Development Single storey side extension, porch to front, detached single storey outbuilding to rear to be used as a garden room, conversion of detached garage room from flat to pitched and alterations to fenestration.

Location 149 Barrack Lane Aldwick

I regret that I am unable to accept your documents as a formal application until the following item(s) have been received or resolved :-

SITE PLAN 1:100

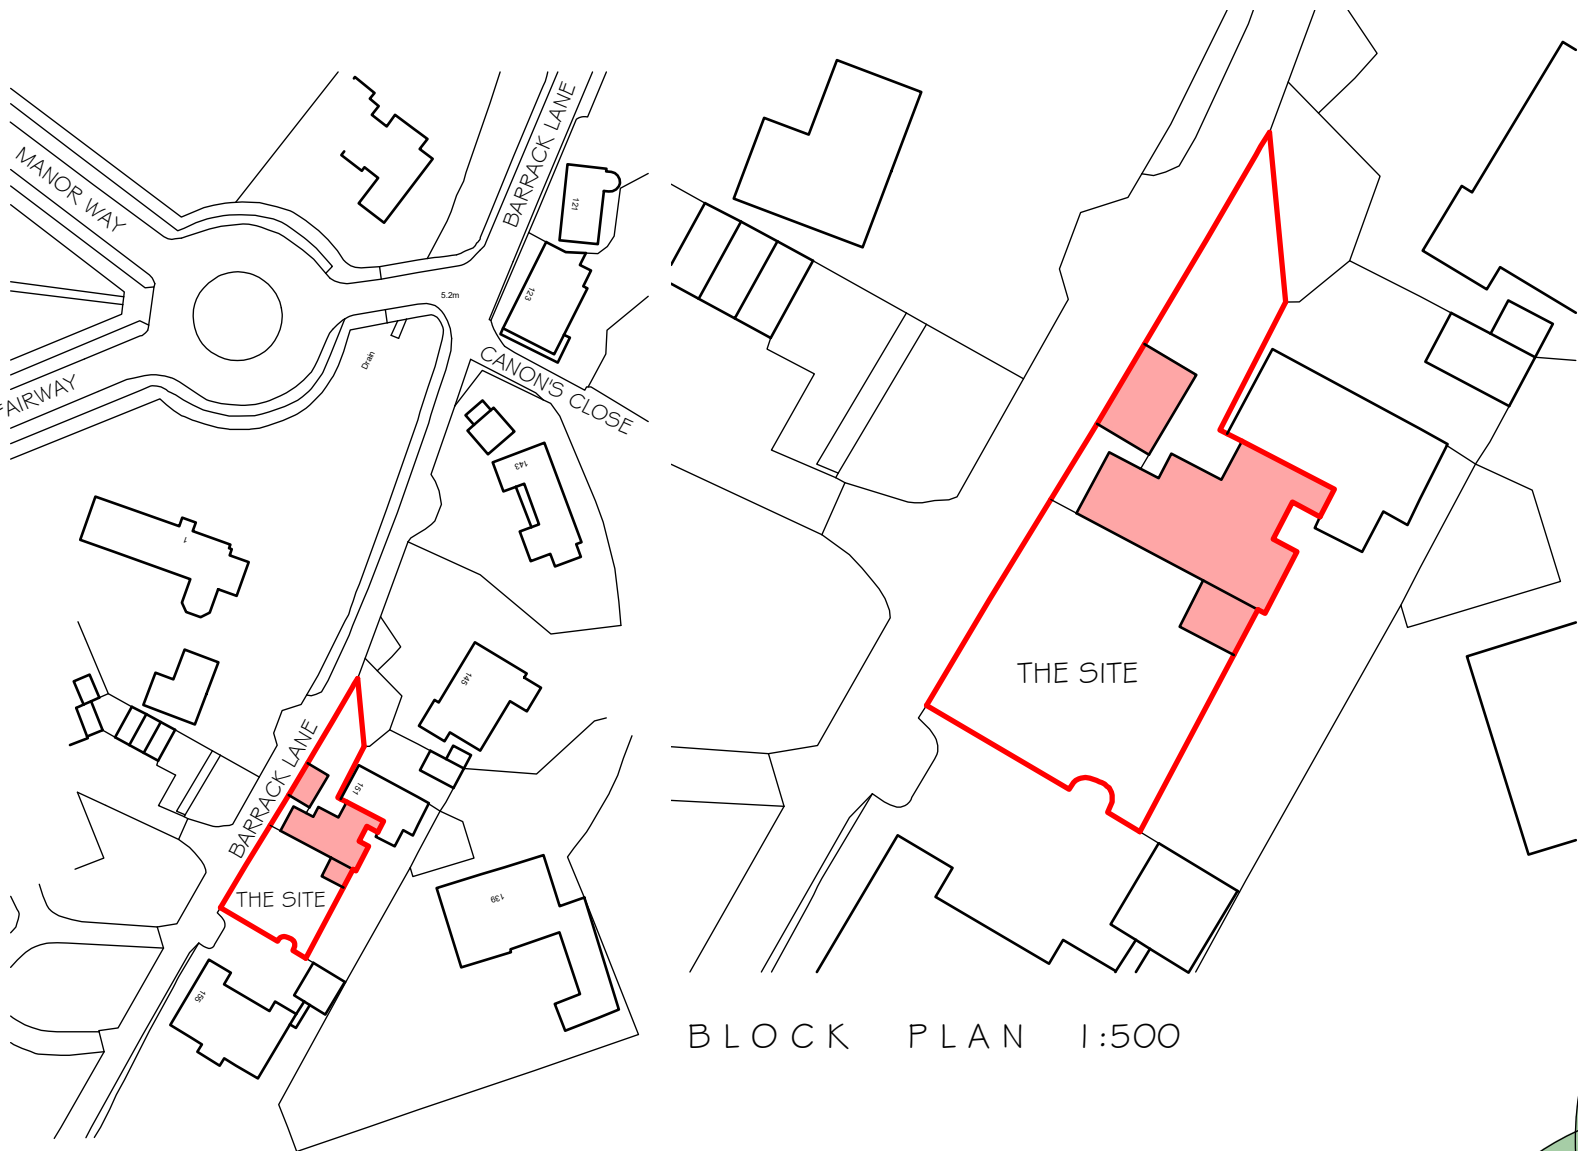
Block Plan

Please include dimensions on the site plan (1:100 version) from all proposed extensions (side and porch) and proposed garden room to all site boundaries.
